CITY OF ALBUQUERQUE

**Re: Garcia's Kitchen , 8518 Indian School Rd. NE - Grading and Drainage Plan
Engineer's Stamp date 11-28-11 (J20/D008)**

Based upon the information provided in your submittal received 01-05-12, the above referenced plan cannot be approved for Building Permit until the following comments are addressed:

DRAINAGE PLAN

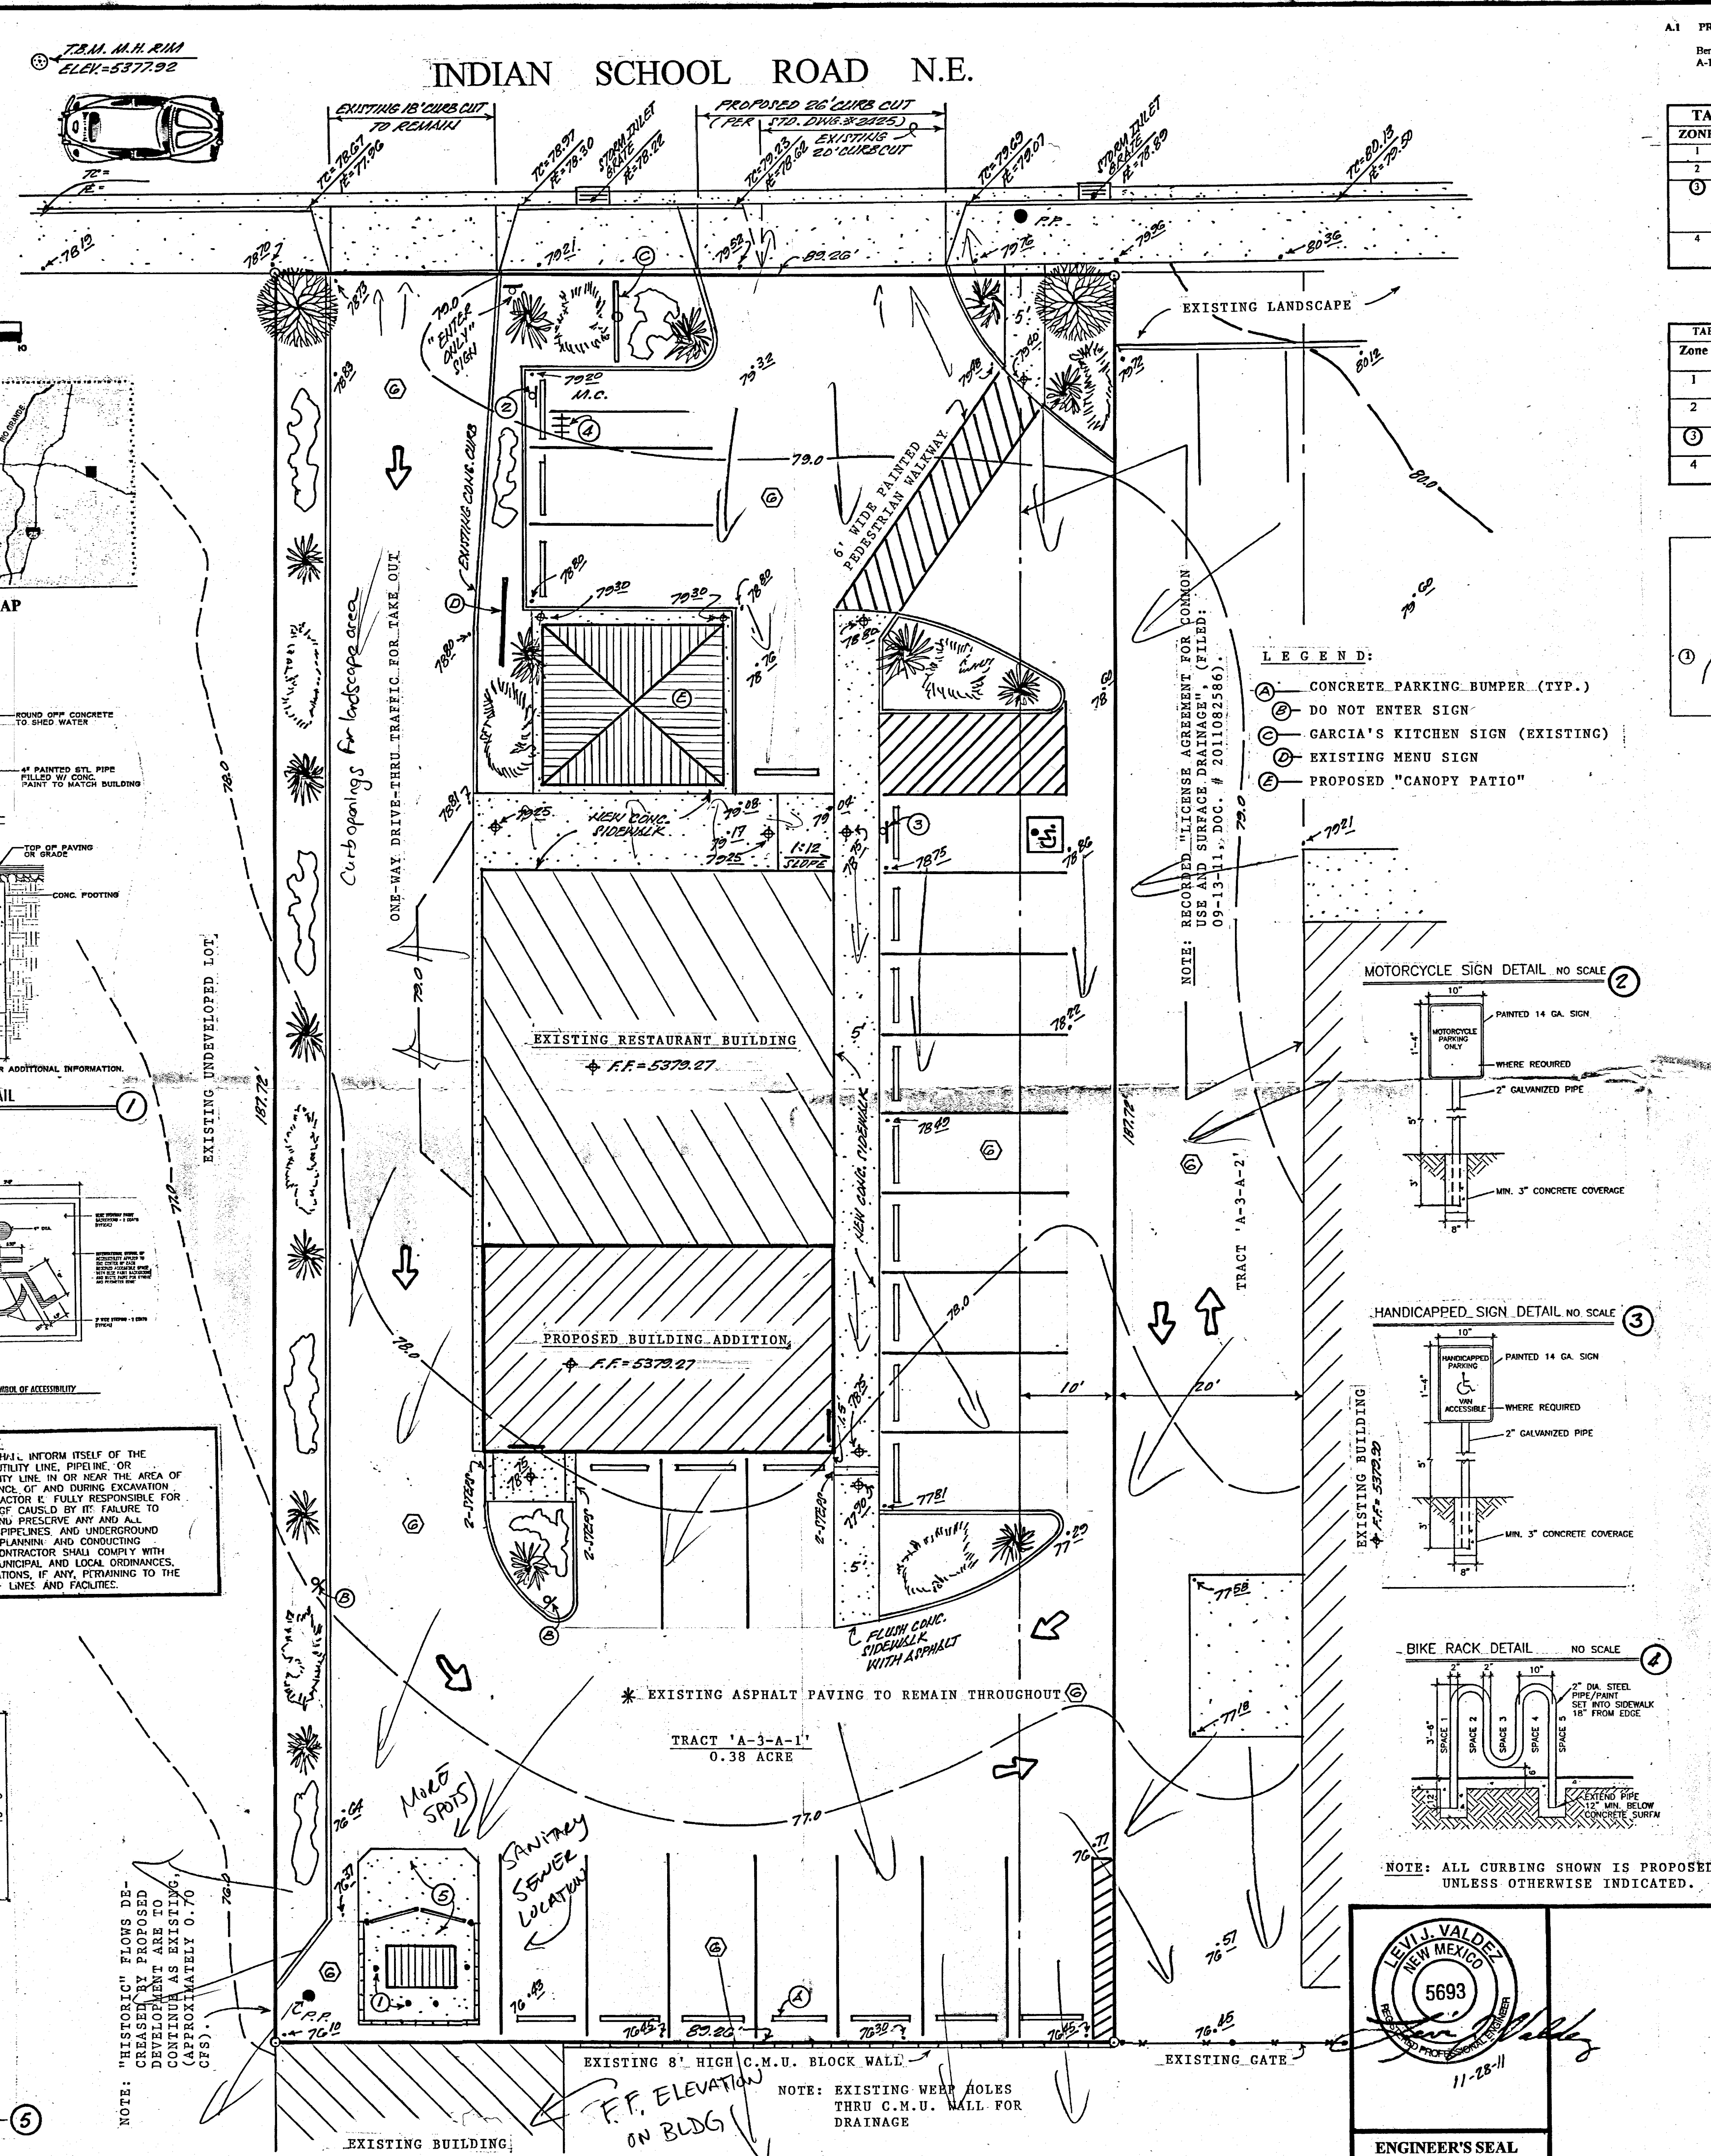
- Hydrology is requesting that you depress all landscaped areas for water harvesting.
- The concrete curb that runs along the western property line should include curb openings to allow for sheet flows into the landscape areas.
- Provide additional spot elevations around the trash enclosure.
- Plan must show the location of the drain connection for the trash enclosure.
